# INDIVIDUAL PLANNING OBJECTION

Waterloo South SSDA — SSD-93222706

5/237 Cope Street, Waterloo NSW 2017 — PT 20 — SP79210

Sawtooth Warehouse Conversion — 237 Cope Street | Individual Objection Template | Deadline: 5:00pm Tuesday 2 June 2026

Drawing Name
Blocks 2 & 3
 Proposed Envelope - Plan

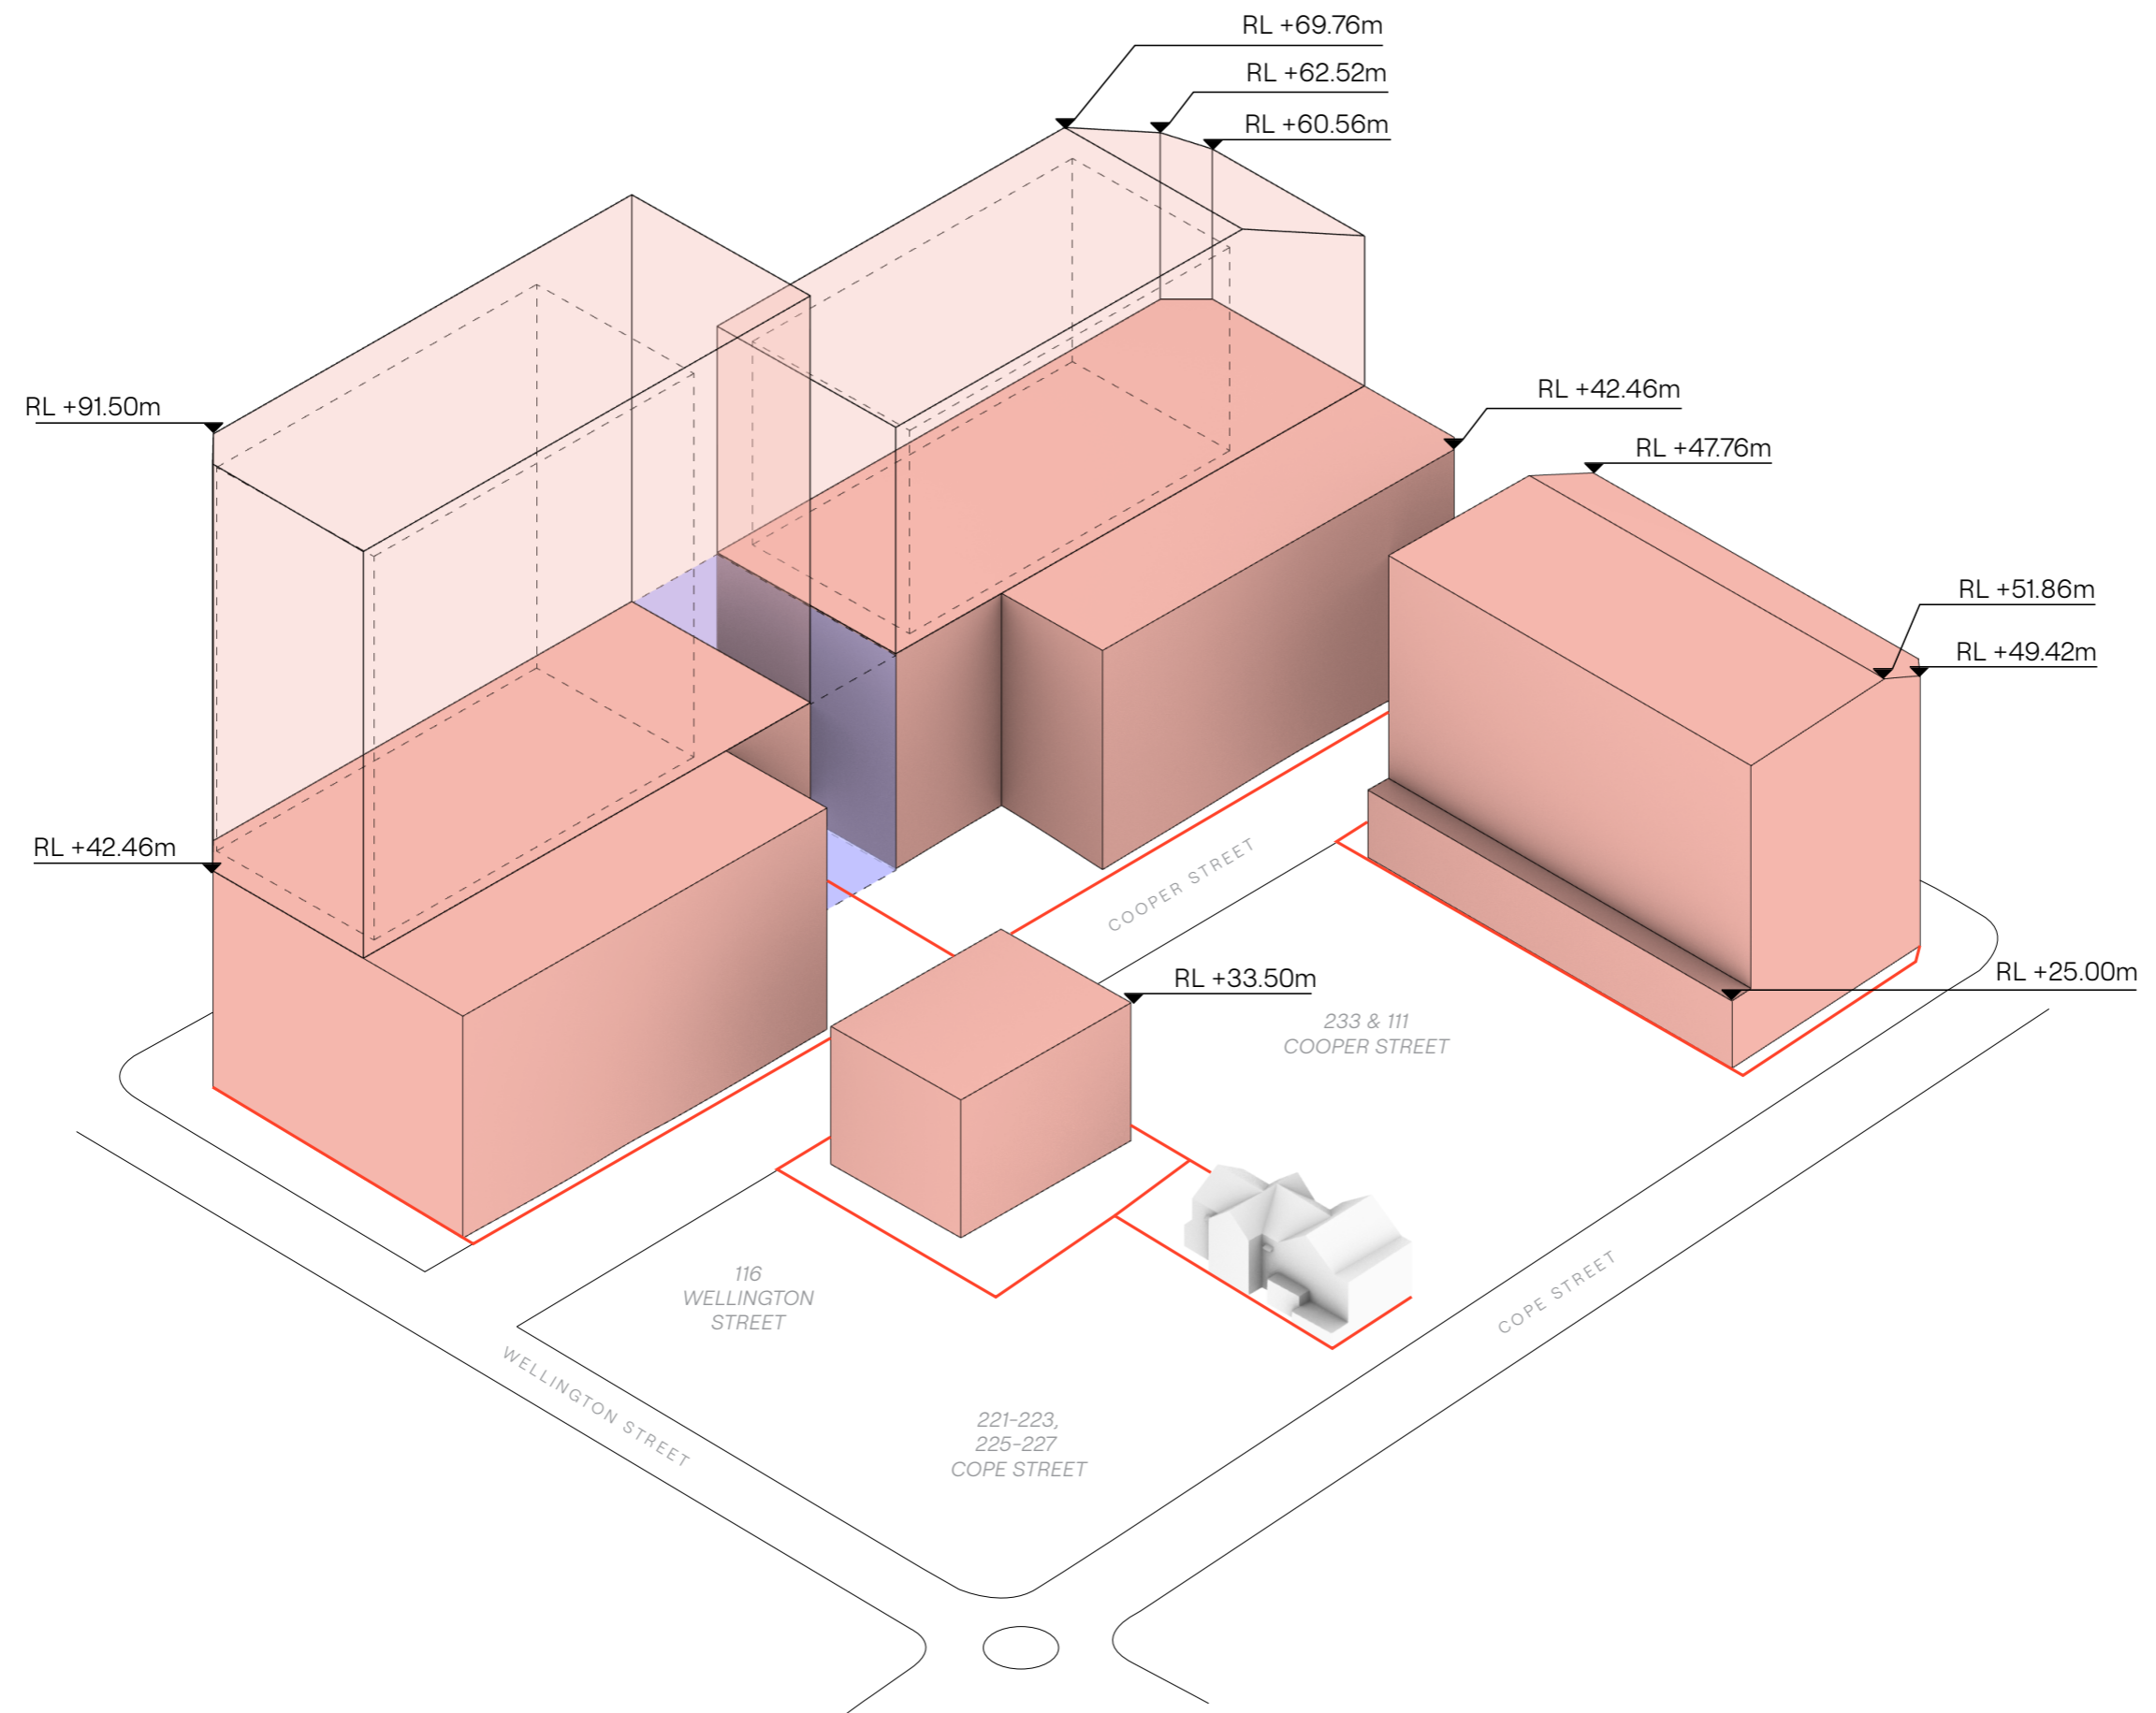
- **Loss of solar access:** The proposed Lot 2D (9 storeys, RL +51.86m, 3m setback from Cope Street) is positioned directly opposite my building. The EIS Urban Design Report confirms Cope Street receives between 0 and 1.75 hours of winter solstice sunlight under the proposed envelopes. No solar access analysis has been conducted for privately owned properties on the western side of Cope Street in breach of SEAR 7.

- **237 Cope Street — architectural solar dependency:** The sawtooth clerestory glazing and apex skylights of my unit are entirely dependent on unobstructed eastern morning solar access (threatened by Lot 2D) and southern sky access (threatened by Lot 3B on John Street, RL +69.76m). Blocking these specific light sources eliminates the architectural character and habitability of my dwelling. This is not a generic overshadowing impact — it is an architectural nullification.

- Require supplementary solar access analysis modelling overshadowing of my property at hourly intervals between 9am and 3pm as required by SEAR 7
- Require a supplementary Visual Impact Assessment with viewpoints from within my property and other privately owned properties on Cope Street
- Require the proponent to provide the comparative analysis of the two-storey height protection removal required by SARP Study Requirement Item 3
- Require a Construction Environmental Management Plan addressing impacts on privately owned properties on Cope Street prior to demolition or excavation
- Appoint the Independent Planning Commission as consent authority
